From: Simon Davis

Sent: 29 May 2026 10:02

Subject: RE: WA/18/26/PL - Land off Arundel Road

A	16.03.26	Site Layout amended	CV	KE
Rev	Date	Revision Details	Dr	Ch

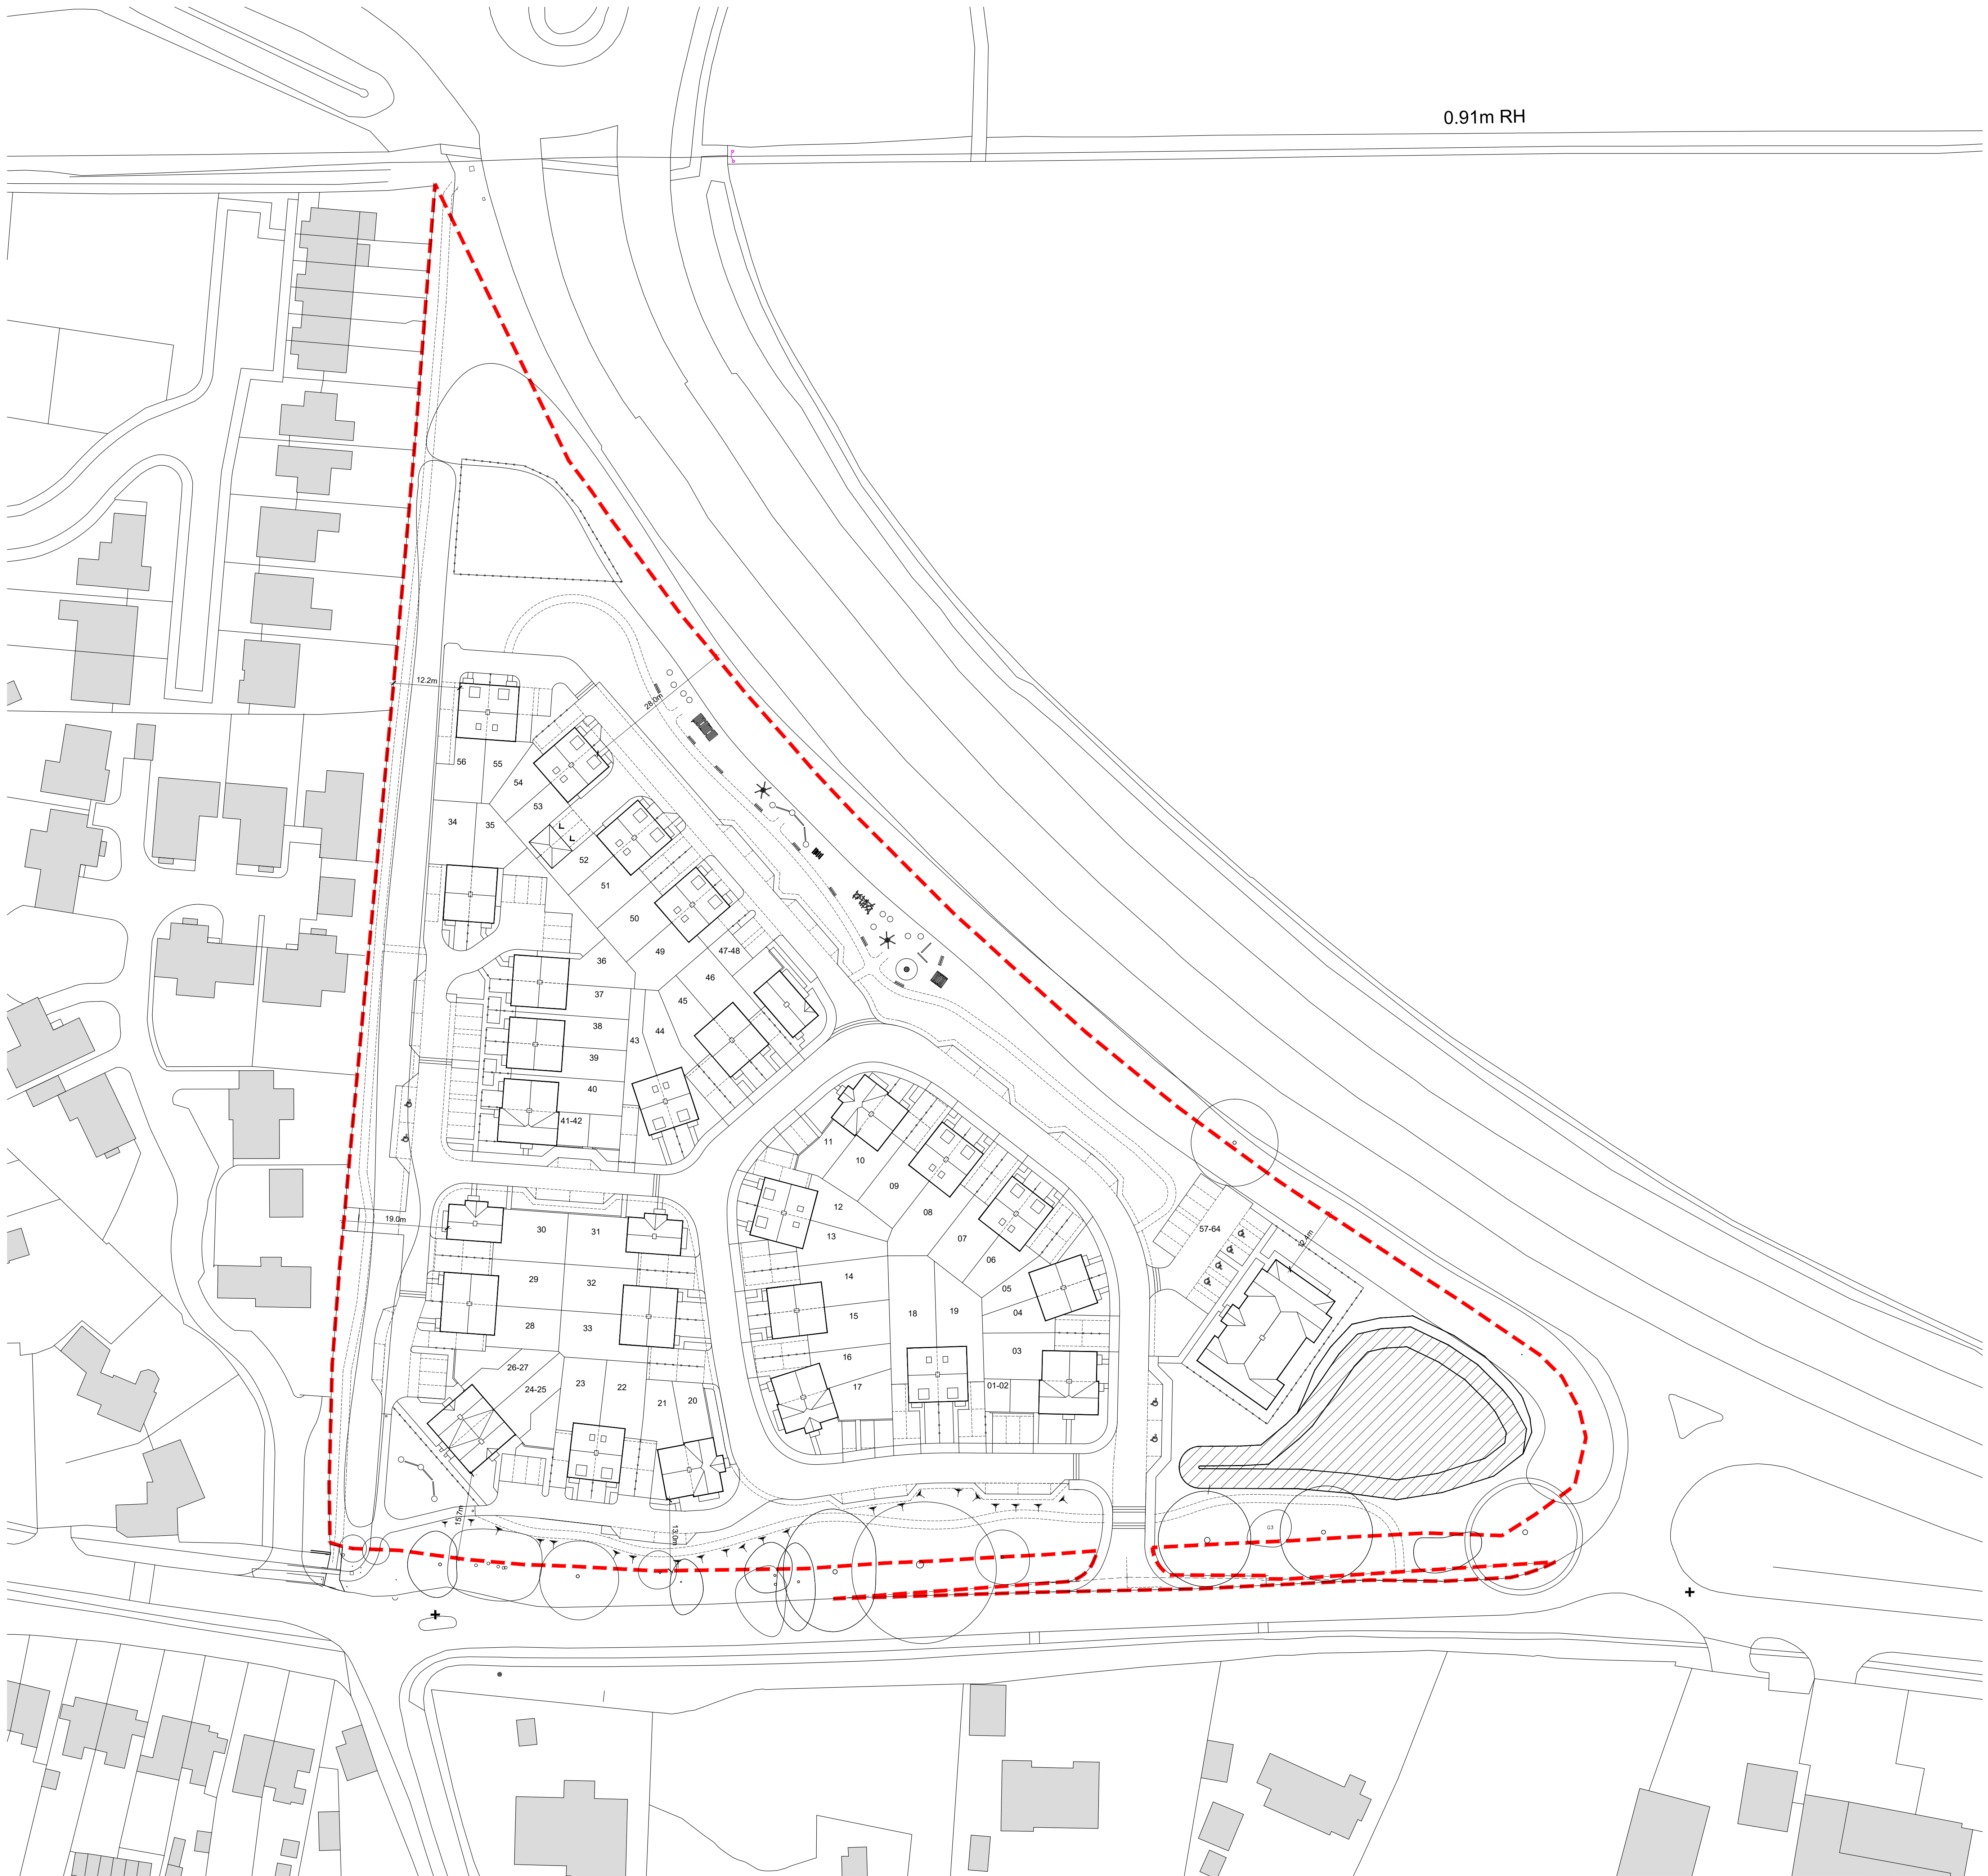
Regarding the remaining interface shortfalls, as below, these may be acceptable if it can be demonstrated that windows do not face each other.

- 1/2R to 19S is 13m (14m)
- 11R to 12S is 13.5m (14m)
- 31F to 43F is 14.9m (16m)
- 30F to 41/42S is 12m (14m)
